2190947

Response to Request for Information Powerhouse Parramatta – SSD 10416

To	WMA DPIE	18 January 2021
Copies	Tom Kennedy	Reference number
From	ARUP	File reference Tech Note 3000
Subject	Powerhouse Parramatta – DPIE Flood RFI's

Figure No	Issue
P1.0-PMFD	1

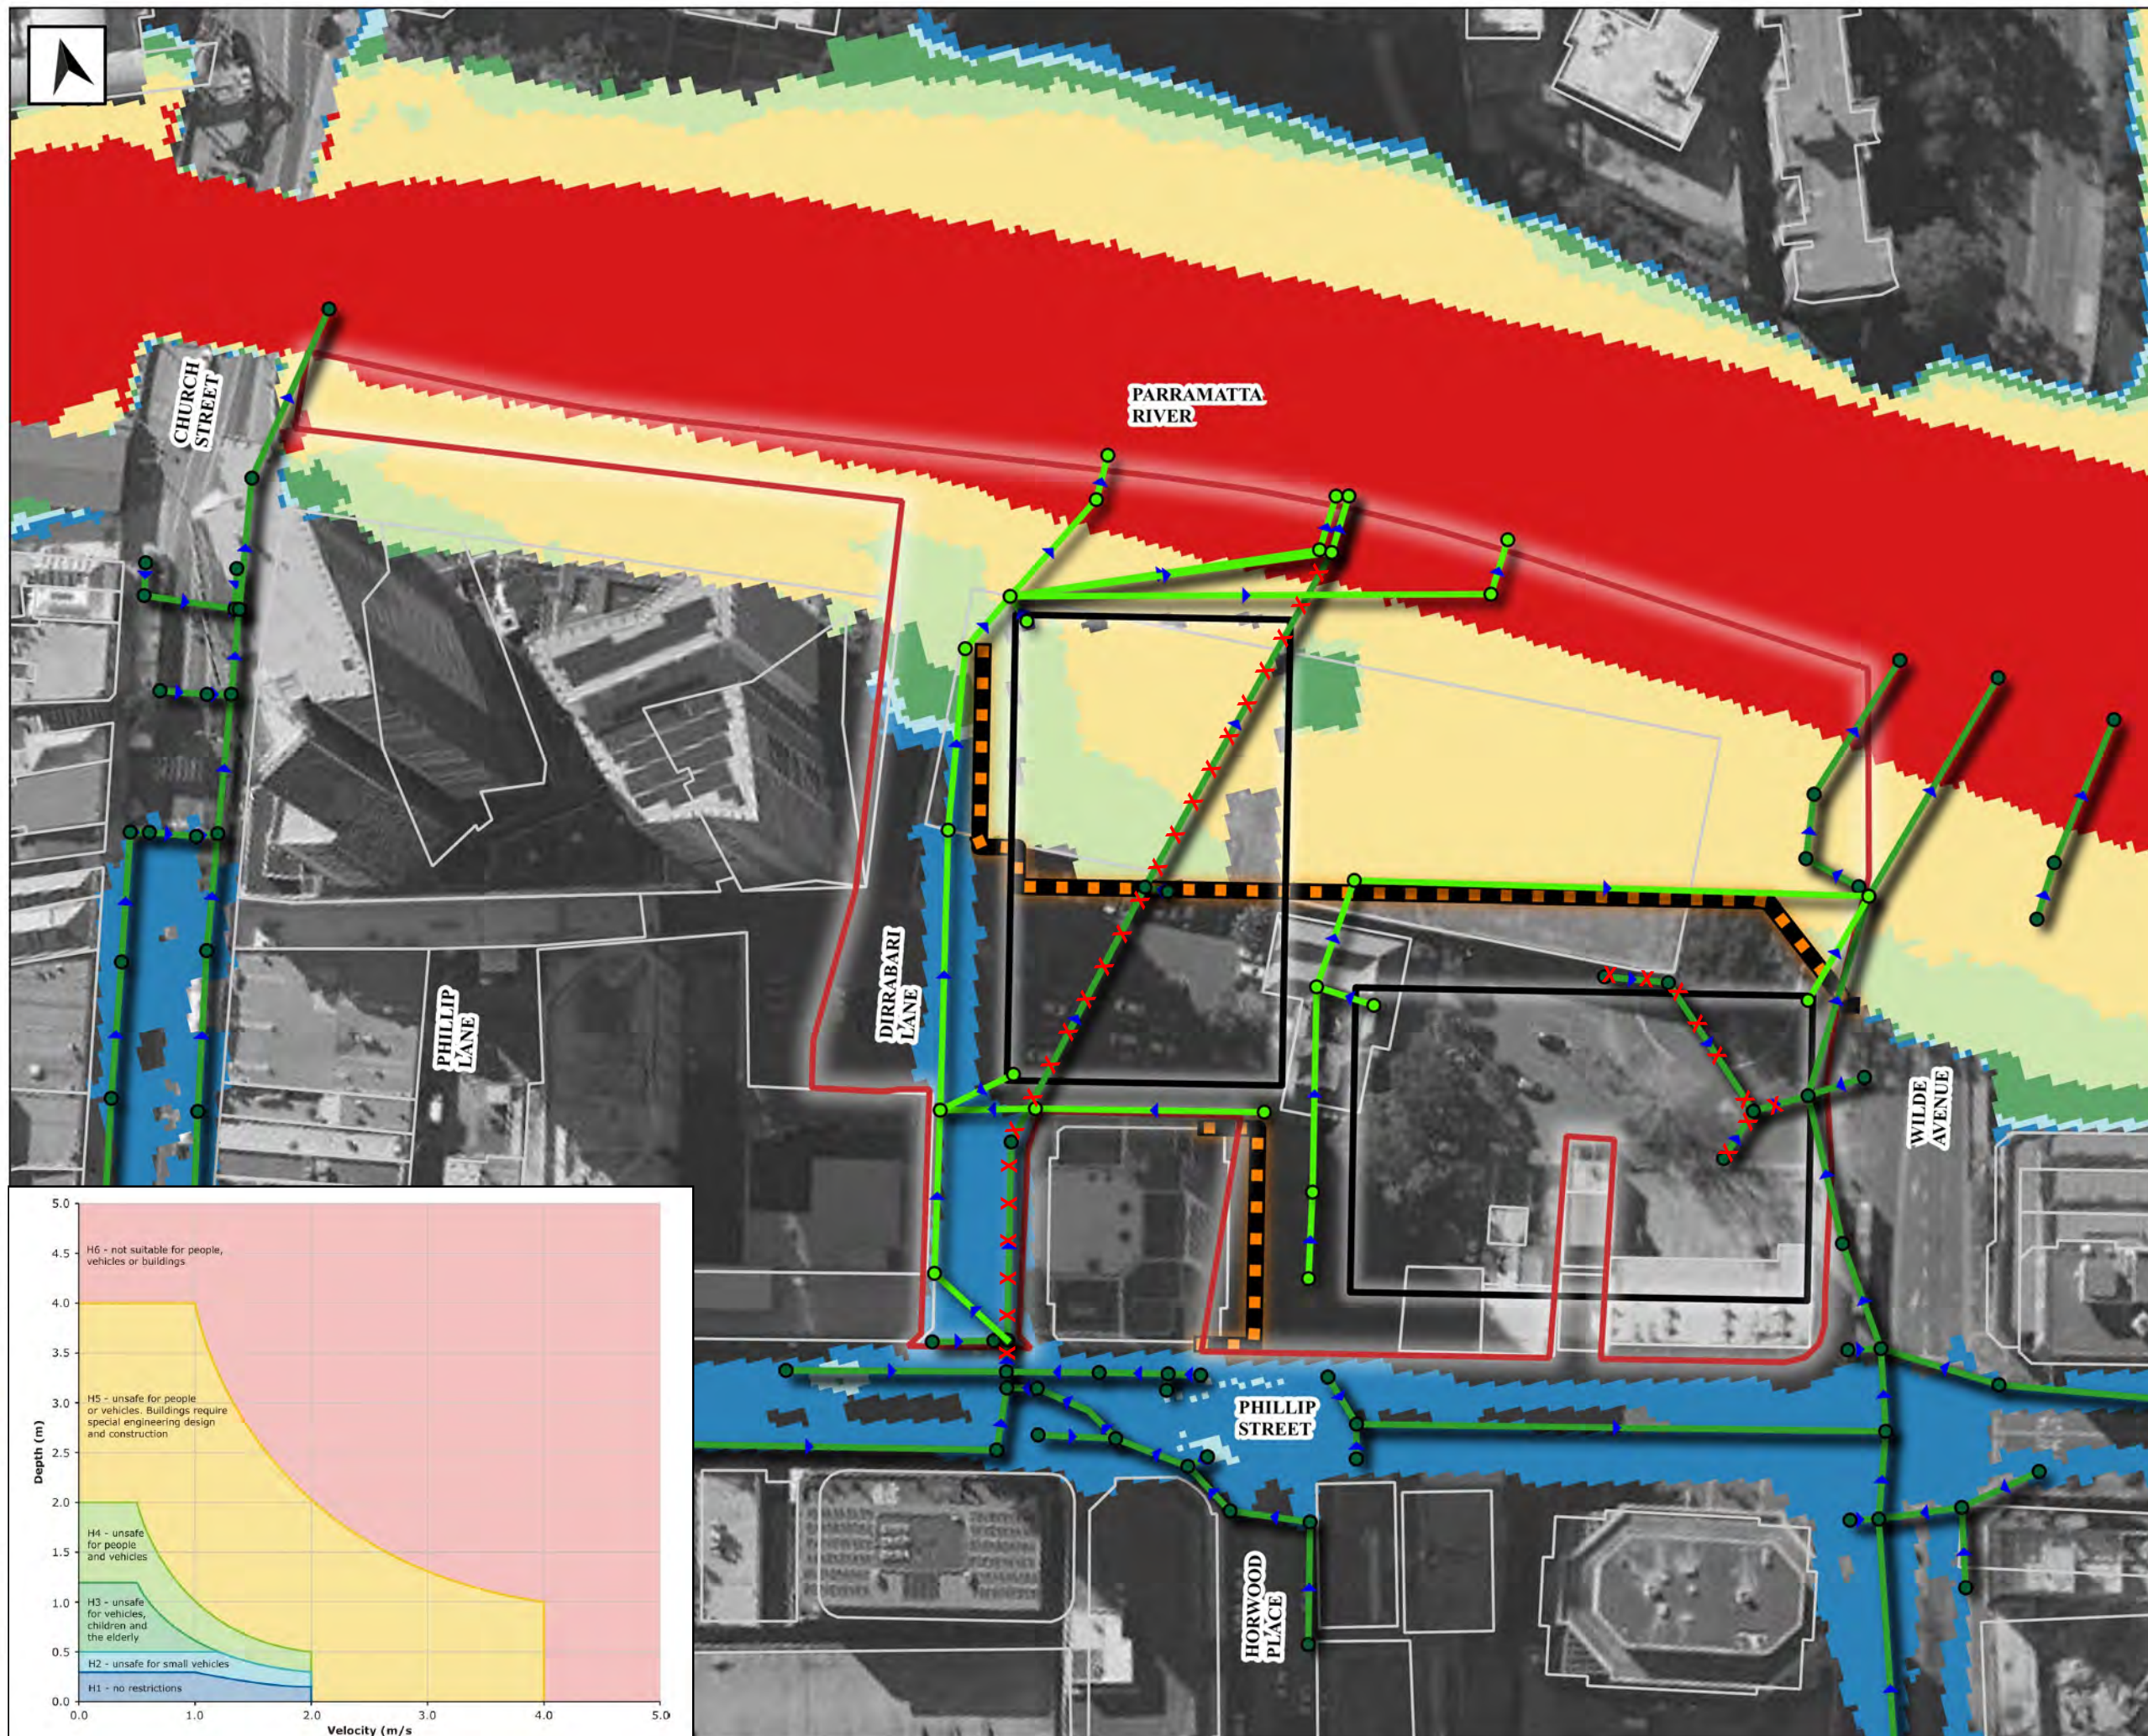
The reporting to date has focussed on flood impacts up to and including the 1% AEP flood. To understand the magnitude of impacts for rarer floods, impact maps are attached to this technical note for the 1:1000 AEP flood and the Probable Maximum Flood (PMF). These maps are presented in Figures P1.19-0.10A-MOF and P1.19-PMFA-MOF.

- Impacts for the 1:1000 AEP flood on private property outside the site are less than 10mm except for a few small areas. One is adjacent to 330 Church St and another is a small area in Phillip St (which is likely to be due to modelling accuracy issues).
- Impacts for the PMF are less than 10mm for area along the Parramatta River. However, the project would result in impacts in the order of 50mm in the Parramatta CBD. Flood depths for the PMF in these streets would already be in the order of 2m to 4m.
